**RE: NW Bicester: Hawkwell Village: Outline application (with all matters reserved except for Access) for a mixed use development of up to 3,100 dwellings, local centre, employment areas, schools, green infrastructure and associated infrastructure (reference 21/04275/OUT)**

1. This document is prepared on behalf of Bucknell Parish Council in response to the further submissions dated the 24<sup>th</sup> March 2023 made by David Lock and Associates on the behalf of the developer Applicants (hereafter referred to as “The Applicants” or the “developer”) and the various new material recently produced in support of the application which has been submitted by the Applicants throughout February, March and April 2023, with the latest technical documents in support being served as late as the 18<sup>th</sup> and 19<sup>th</sup> April 2023.

Bucknell Road to be closed to vehicles,
Maintained as pedestrian / cycle route

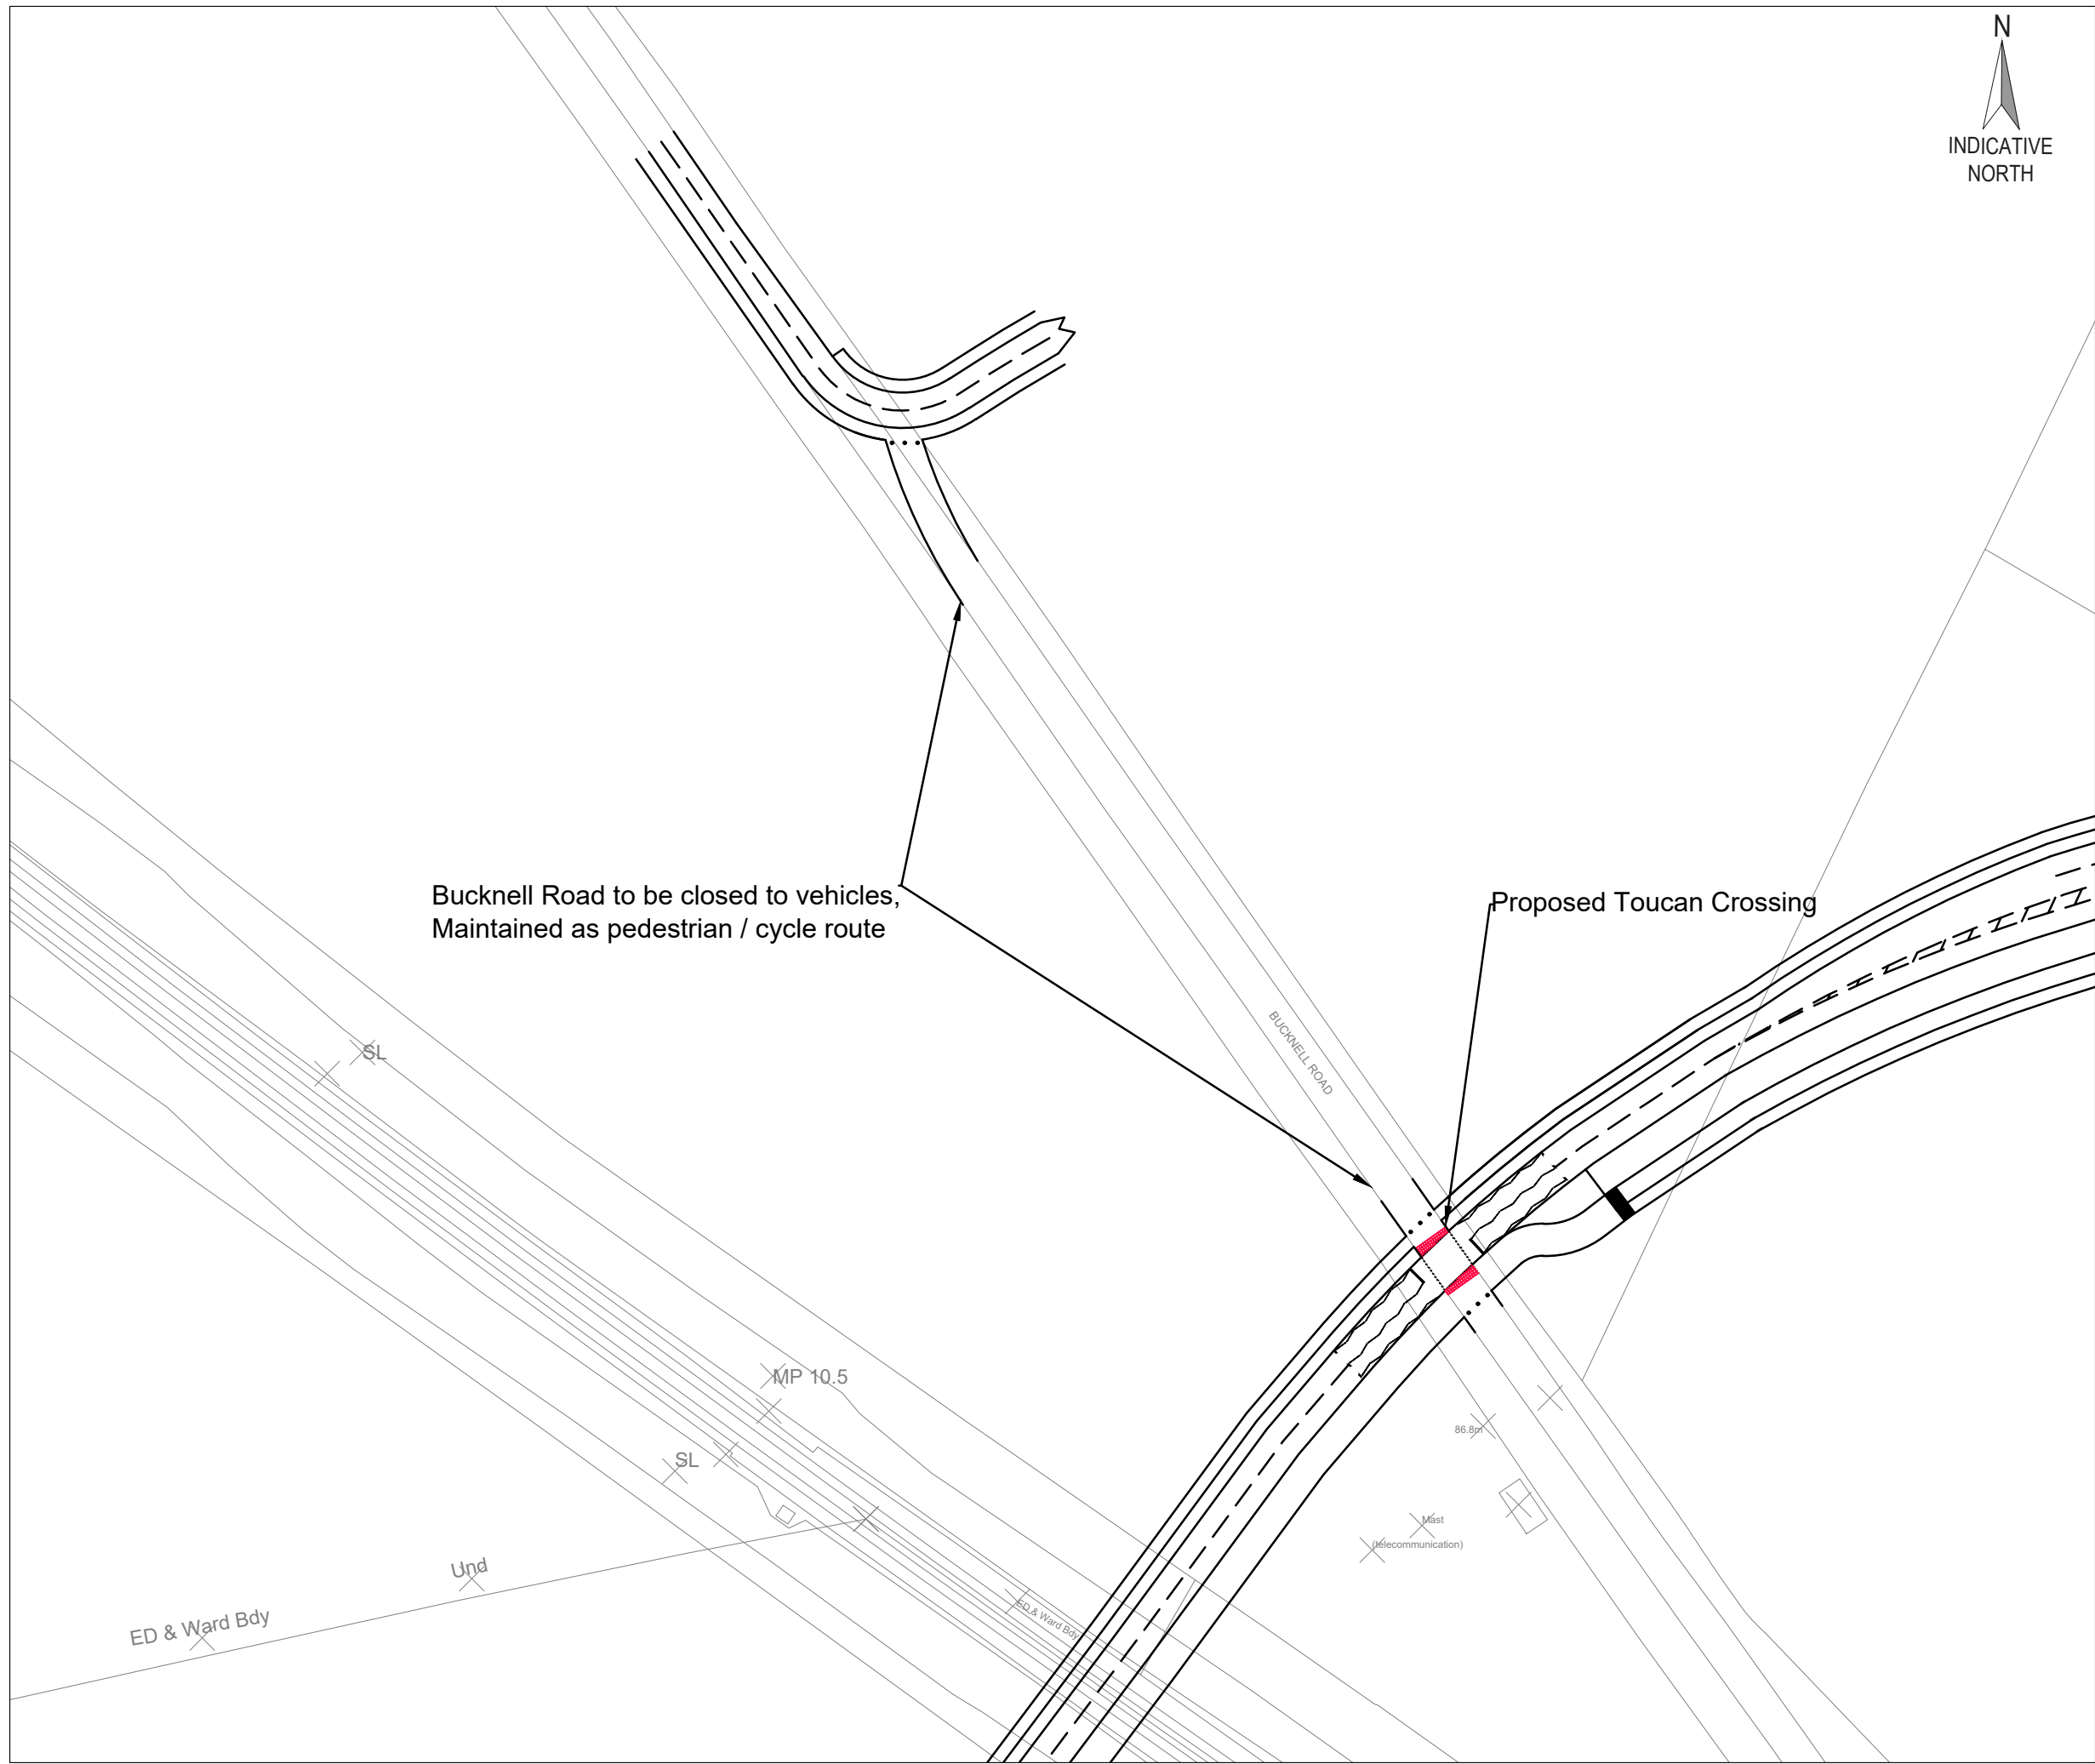
“a) Ref 17 and 18: Further clarification is required on how these junctions have been coded in the 2031 scenario. The network in the area was proposed to change significantly in the area as a result of the A4095 realignment (as per the layout permitted under 14/01968/F), with Bucknell Rd north being closed to vehicular traffic north of the existing railway bridge, Lords Lane forming a priority junction with Bucknell Road close to the existing roundabout and at its northern end a signalised junction with the realigned A4095 close to its existing alignment, and a bus only link leading up from Bucknell Road to the main site access junction on the Strategic Link Road;....

**The table shows a clear impact here. The interim mitigation scheme referred to in the table is not accepted by OCC.**

It's understood that the applicant will shortly propose permanent changes to the network in this area, to prioritise sustainable transport, and **these arrangements will**

**require detailed modelling.** However, early delivery of the footway/cycleway alongside the railway will be important to limit vehicular impact.
